FALL MOUNTAIN FARM
16300 MOUNT HERMAN LANE
MONUMENT, CO 80132
SITE DEVELOPMENT PLAN

SHEET TITLE: SITE DEVELOPMENT PLAN

Site Development Plan_V1.pdf Markup Summary

SHEET TITLE: **SITE DEVELOPMENT PLAN**

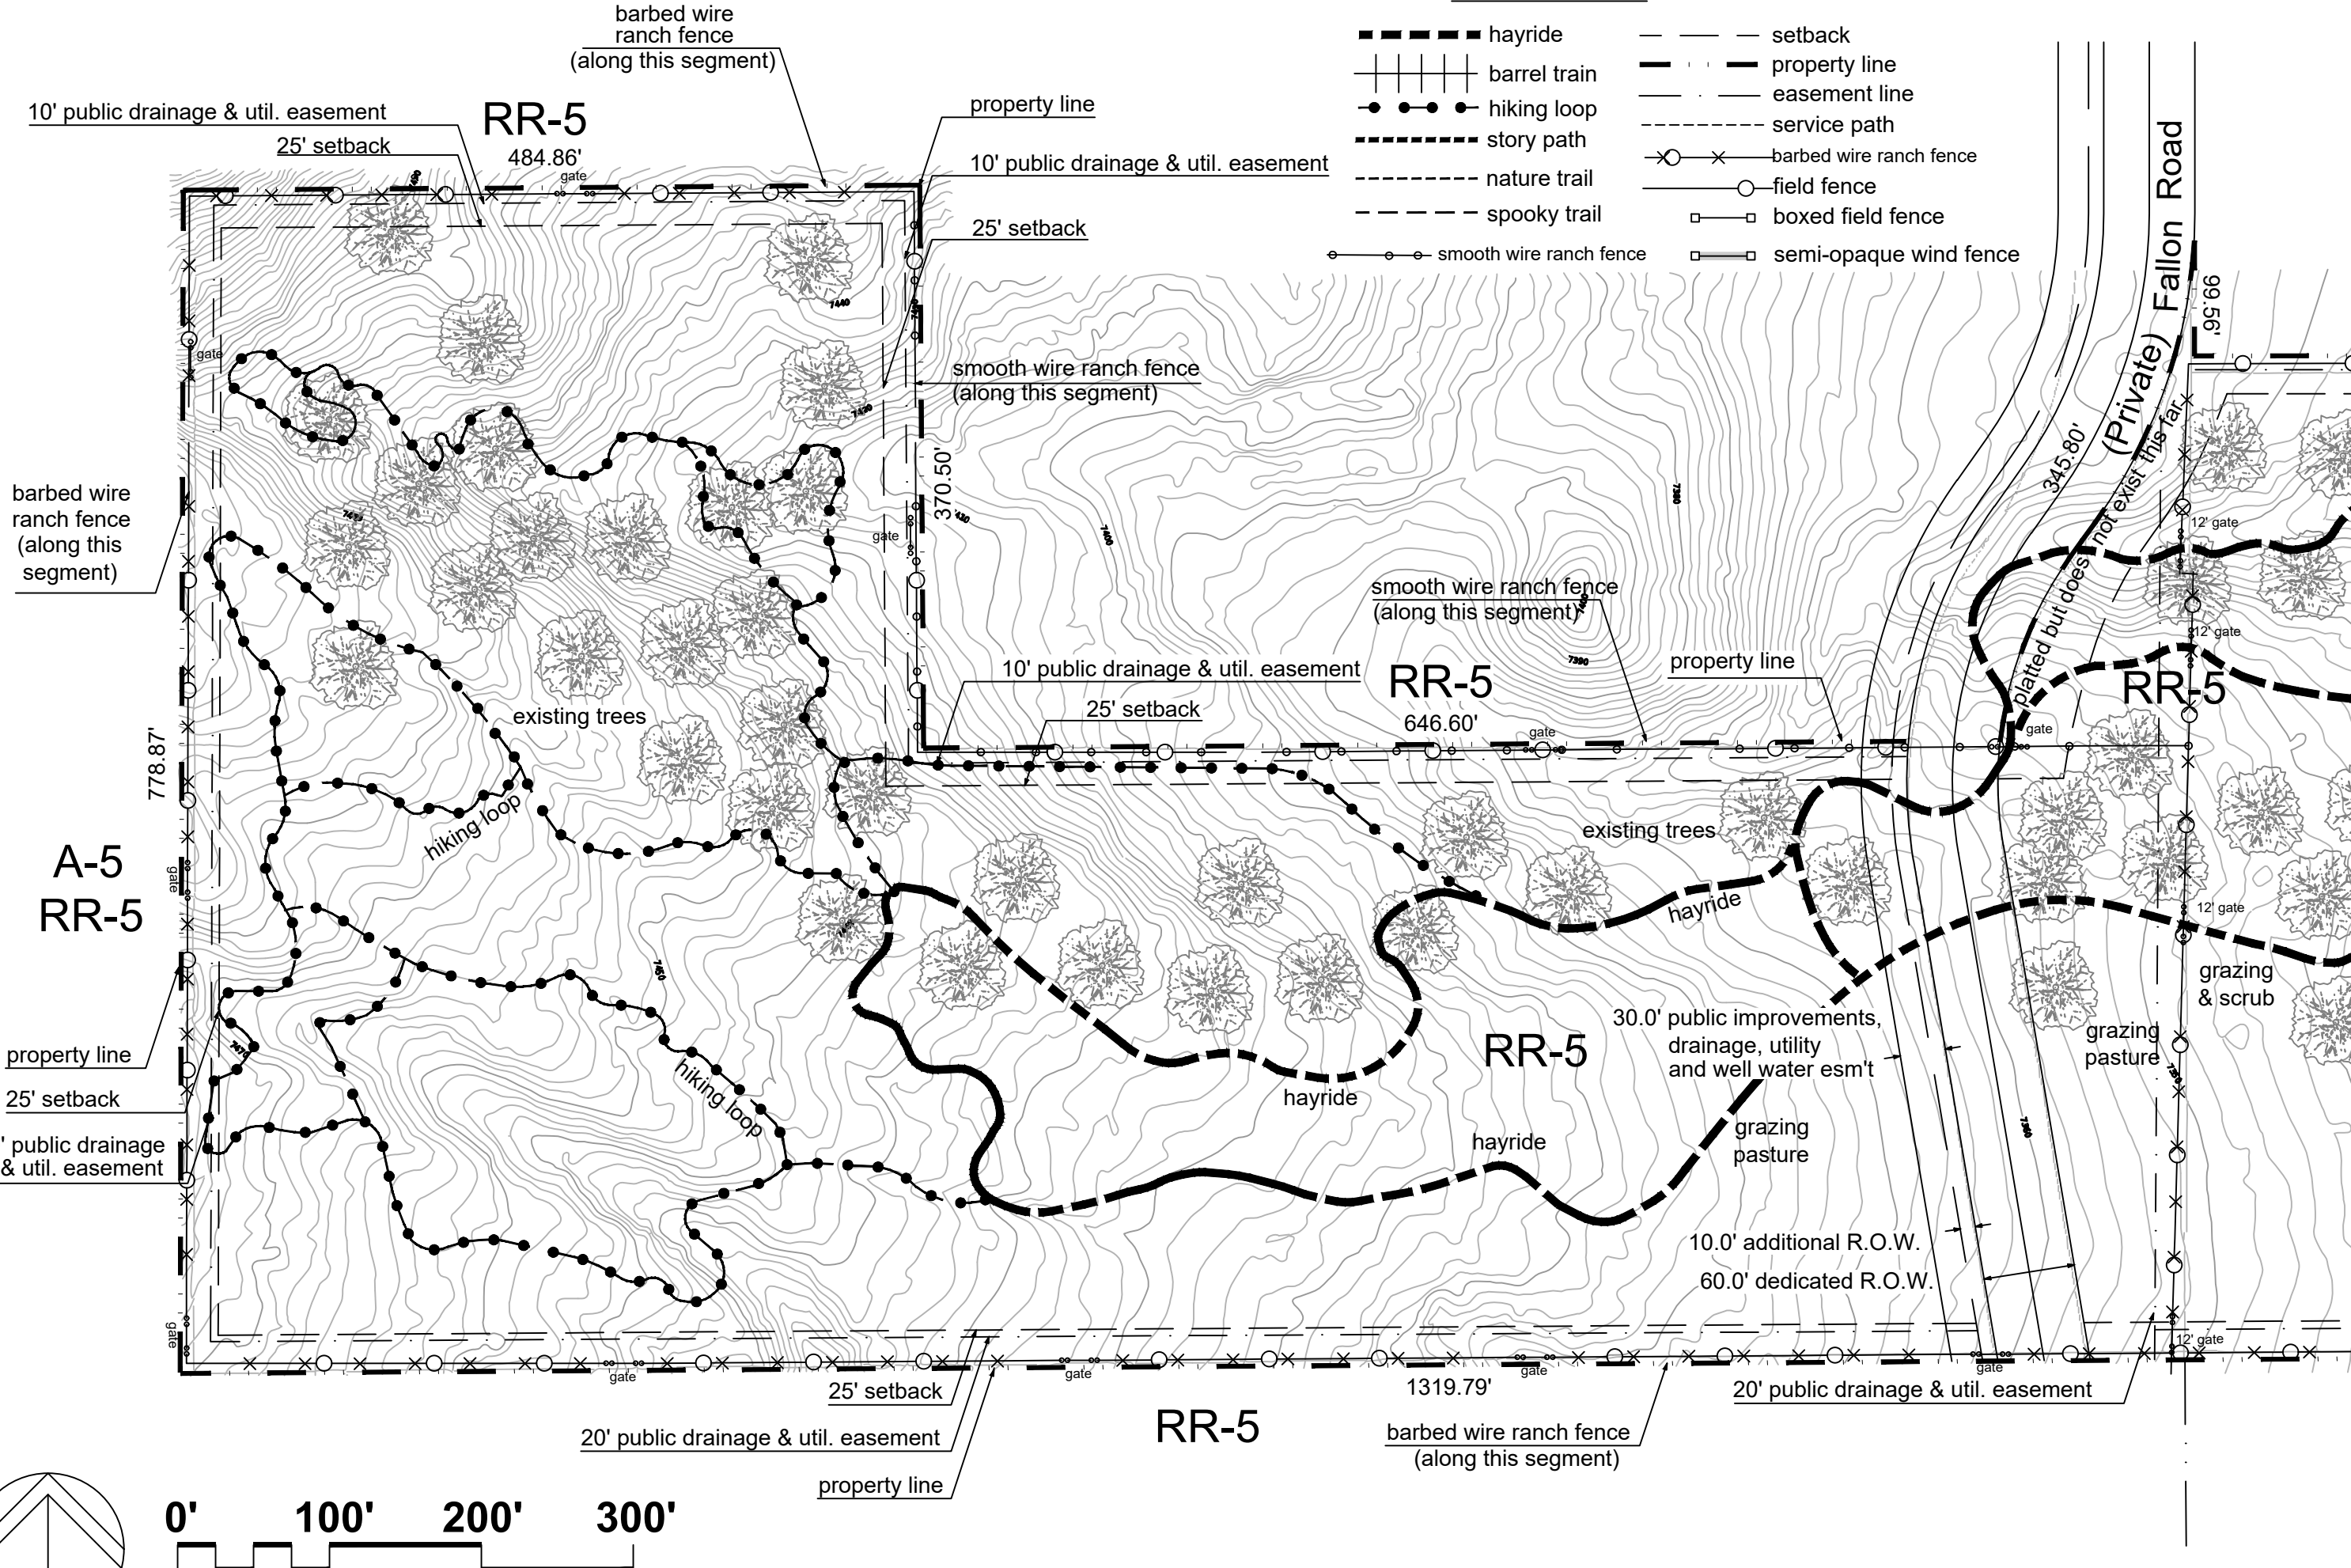
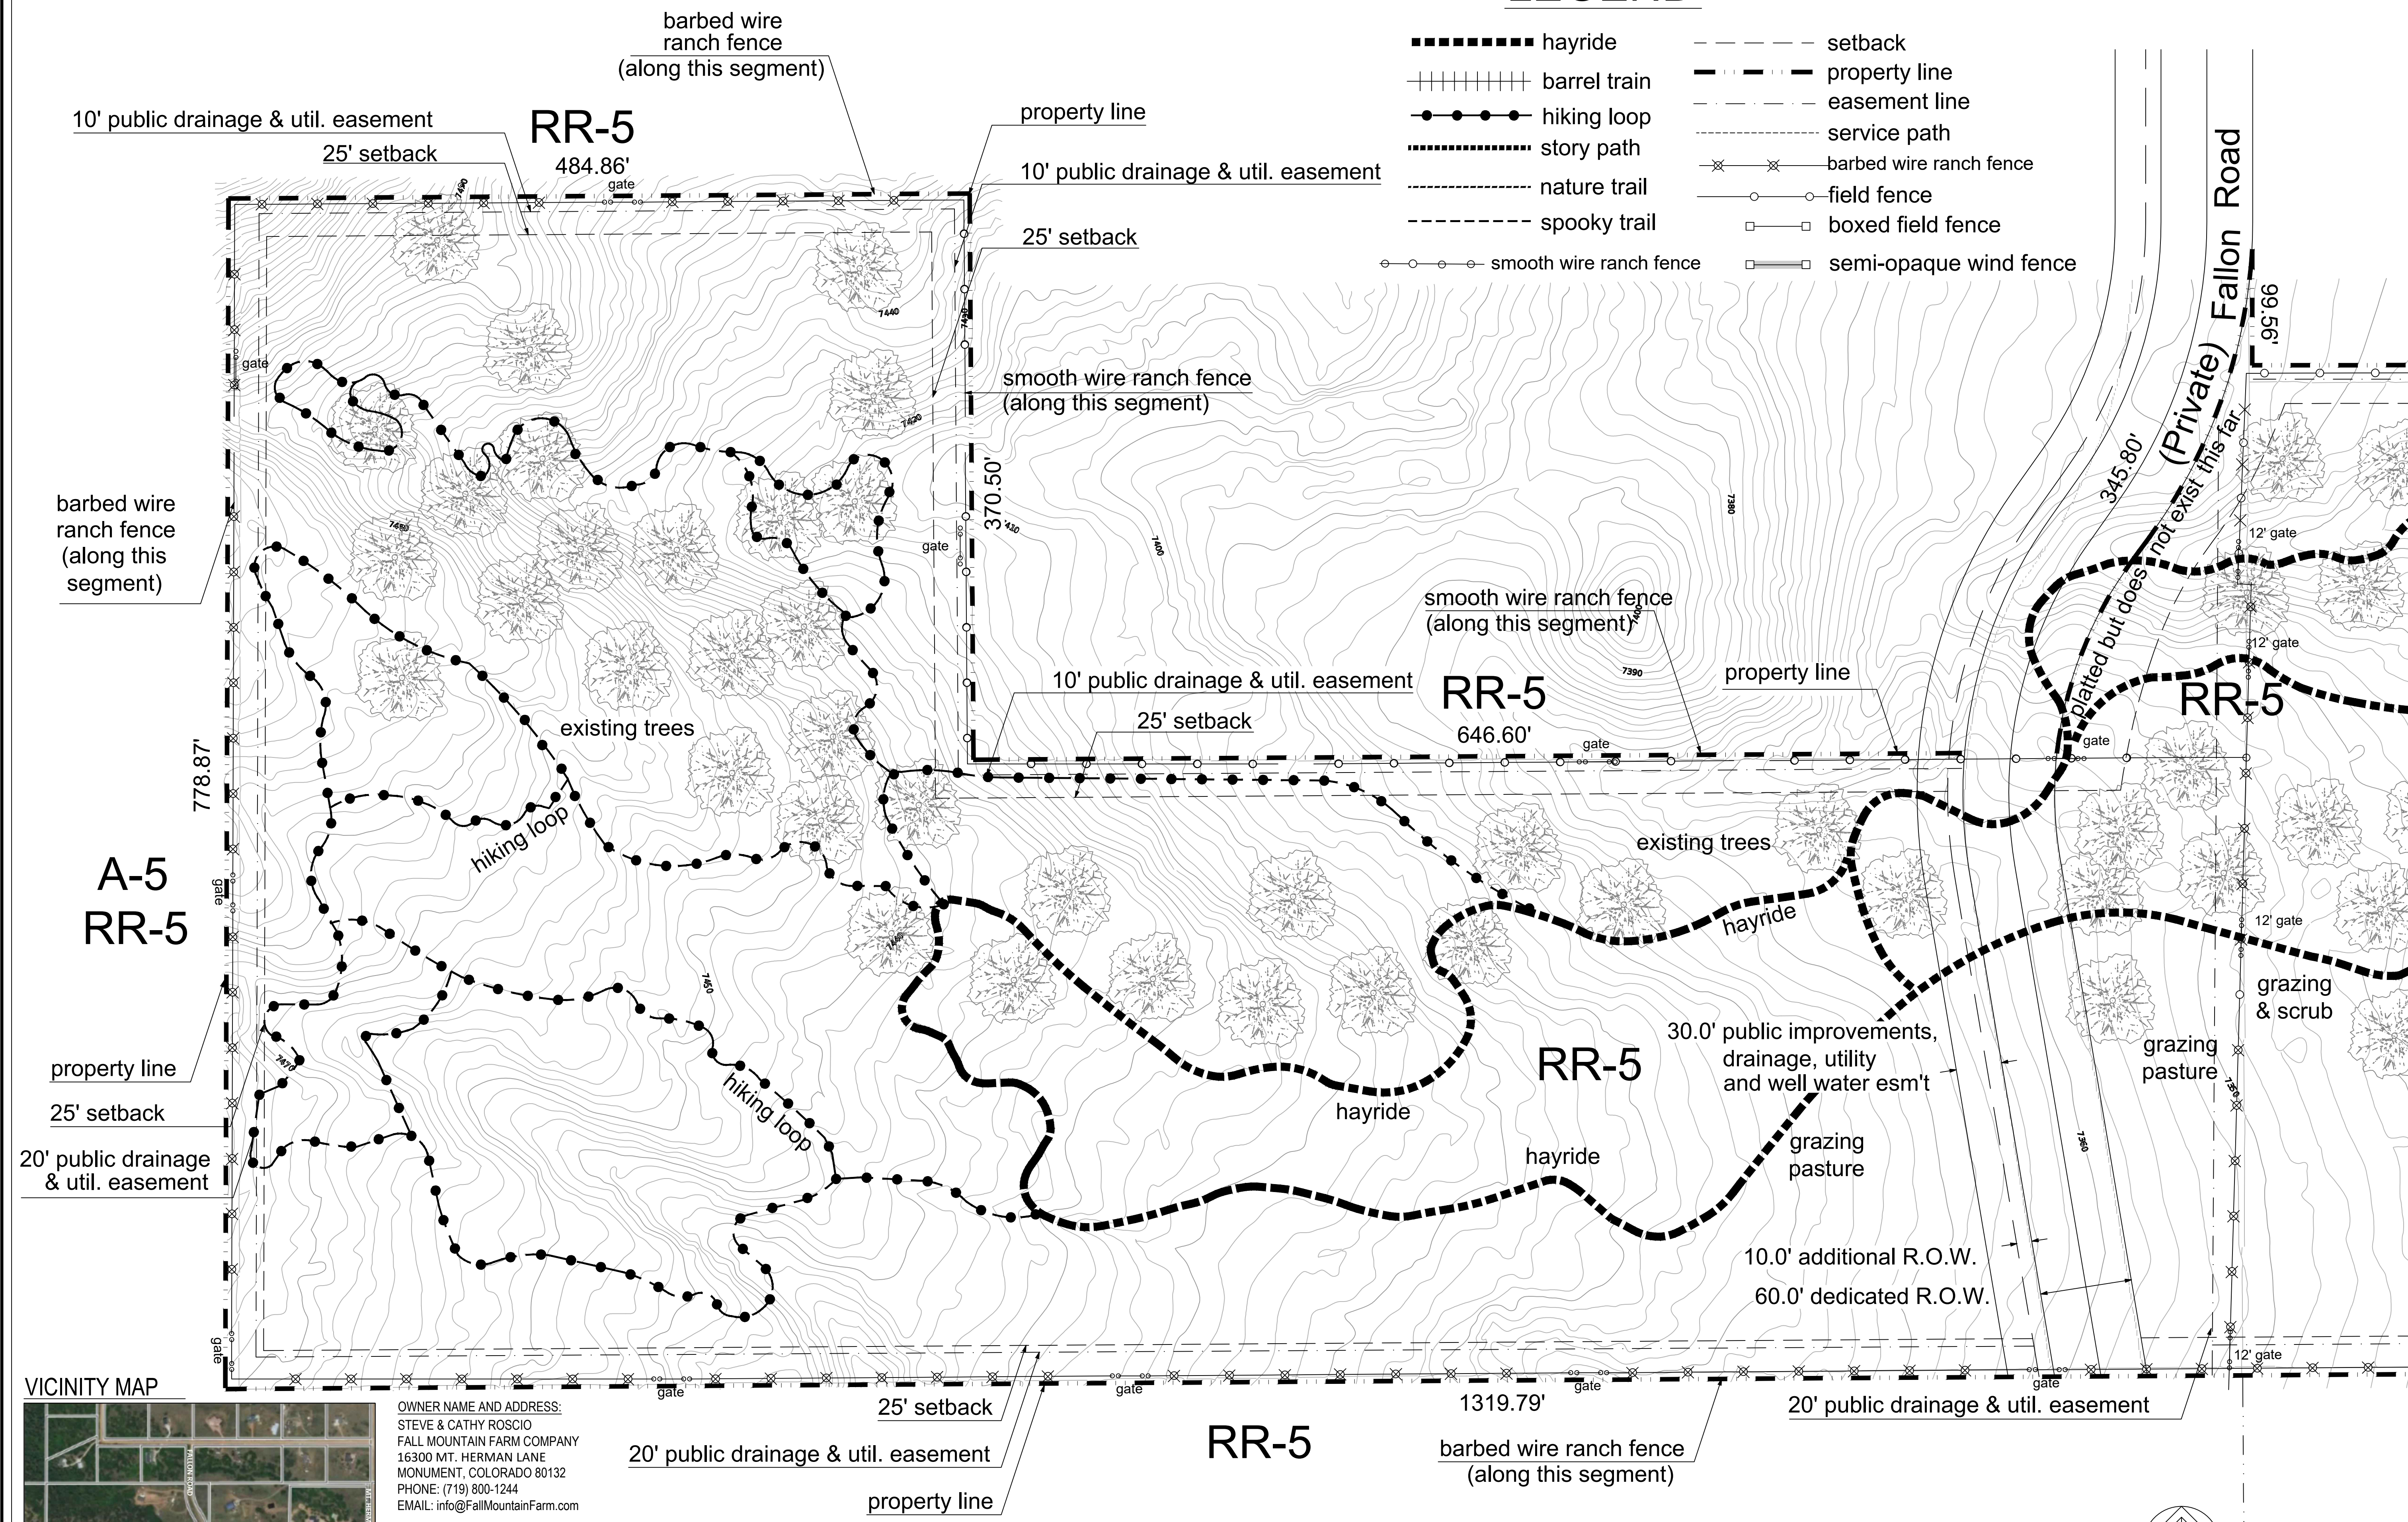
Verify combined acreage

Verify total SF

Please add Planning and Community Director

Please add PCD File No. PPR-2246

Provide address for each parcel

Please label SF of each building

New ticket booth/ Produce Storage Shed?

Verify all property line dimensions per plats 13325
& 8287

Show sign on this plan

Per SDP Checklist, show traffic circulation on site including all points of ingress/egress into the property

Provide SF on all (e) & proposed structures & show all proposed structures on plan (ticket booth and produce shed as shown on the elevation plan)

Per SDP checklist show on plan:

Location of all no-build areas, floodplain, drainage ways and facilities

Location of all garbage receptacles with a graphical depiction of the screening mechanism

The layout and location of all off-street parking, loading and other vehicular use areas, unless otherwise depicted in detail on a separate parking plan. If depicted on a separate parking plan then depiction of the parking areas are required

Please provide a line legend to clearly identify all fences, walls, walking trails, sidewalks, retaining walls, property lines, utilities, easements and ROW
